Our Case Number: ABP-316119-23

Re: DART+ South West Electrified Heavy Railway Order - Hazelhatch & Celbridge Station to Heuston Station, and Hesuton Station to Glasnevin
County Dublin and County Kildare

Re: Notification under Section 37 (1) of the Transport (Railway Infrastructure) Act 2001 (as amended and substituted).

Development: Proposed Strategic Infrastructure Development (SID): Railway Order application for a Railway Order for the DART+ South West Electrified Heavy Railway Order 2023. Subject to approval, the Railway Order will authorise CIÉ to carry out railway works and all works necessary to enable the construction, operation, maintenance and improvement from Hazelhatch and Celbridge Station (County Kildare) to Heuston Station Dublin (circa 16km) on the Cork Mainline

Figure 5-127 Heuston West Station Attenuation Tank Layout

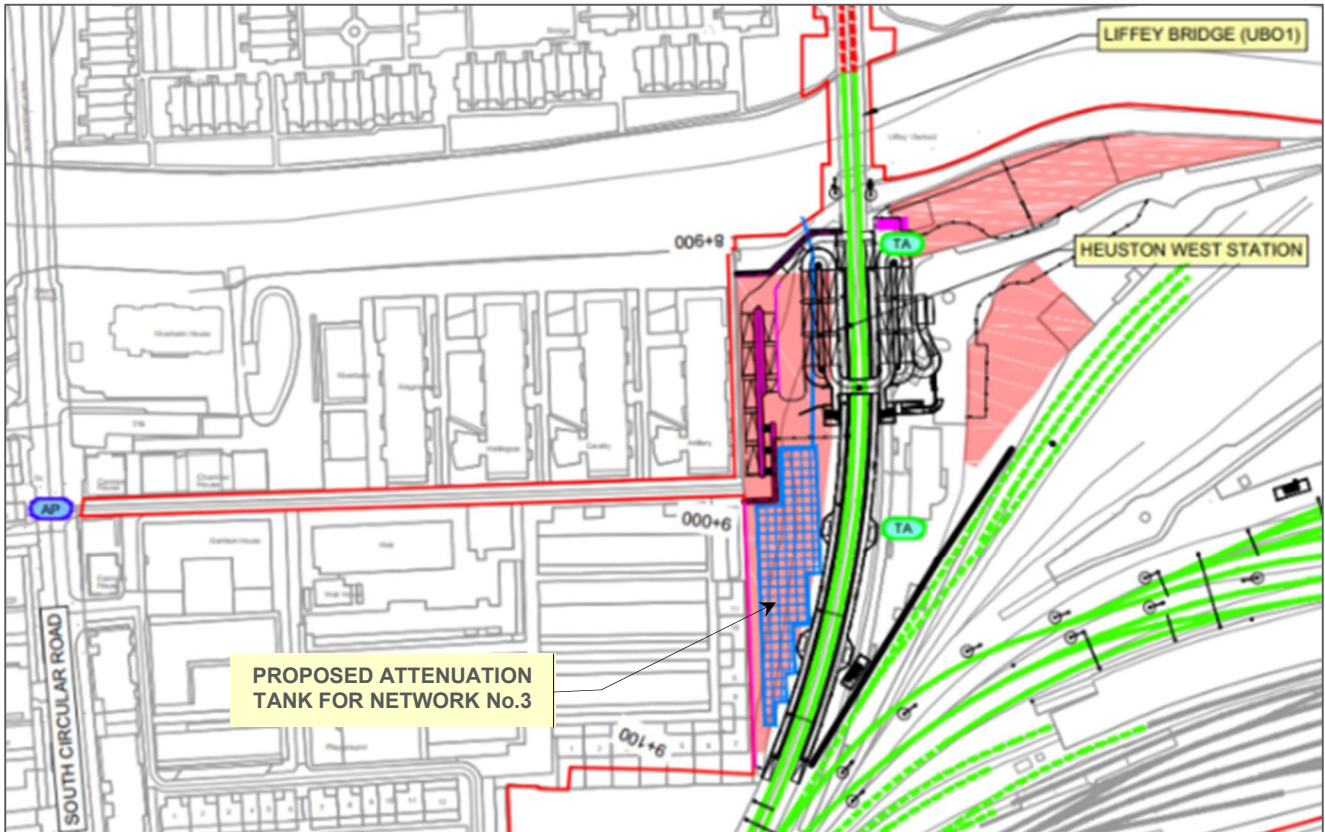
Re. Point 3: The Department welcomes CIÉ/IE's commitment to the inclusion of oil separation on the attenuation tanks to be installed in Inchicore and Heuston Stations which are to outfall to the Liffey as part of the new drainage systems for these areas. It does not seem from the wording of the applicant's response however that it is committed to installing an oil separator or other filtration device on the outfall to the Liffey from the proposed modernised drainage system for the Phoenix Park Tunnel. The Department is concerned, as stated in its' original submission, that following the precautionary principal some form of filtration device should be installed on the tunnel's drainage system before it outfalls to the Liffey as well as on the attenuation tank drainage systems, in order that any potential pollution to the river which might arise from the operation of an increased number of trains through the Phoenix Park Tunnel shall be minimised as far as possible so as to avoid adverse effects on aquatic biota.

However this Department notes from the documentation supporting the present application it appears that no oil separators or other filtration devices are to be installed on the inflows to the attenuation tanks which are to be constructed in Inchicore and Heuston Station and which will then outfall to the Liffey as part of the new drainage system serving the DART+ South West project. Similarly though the Phoenix Park Tunnel drainage system is to be modernised as part of DART+ South West, no oil separator or other filtration device is proposed to be installed on the system's outfall to the Liffey which is to be retained in its present format. This Department considers that on the precautionary principal oil interceptors or other filtration devices should be installed on the above mentioned drainage systems out-falling to the Liffey so as to avoid any increased contamination of runoff with hydrocarbons during the operational phase of DART+ South West due to the planned higher number of train movements it is to cater for. Such an approach should assist in maintaining water quality in the Liffey to sustain all the biota living in or dependent on it including SCI species, and also river lamprey, salmon, and otter which are species included in Annex I of the Habitats Directive (92/43/EEC).
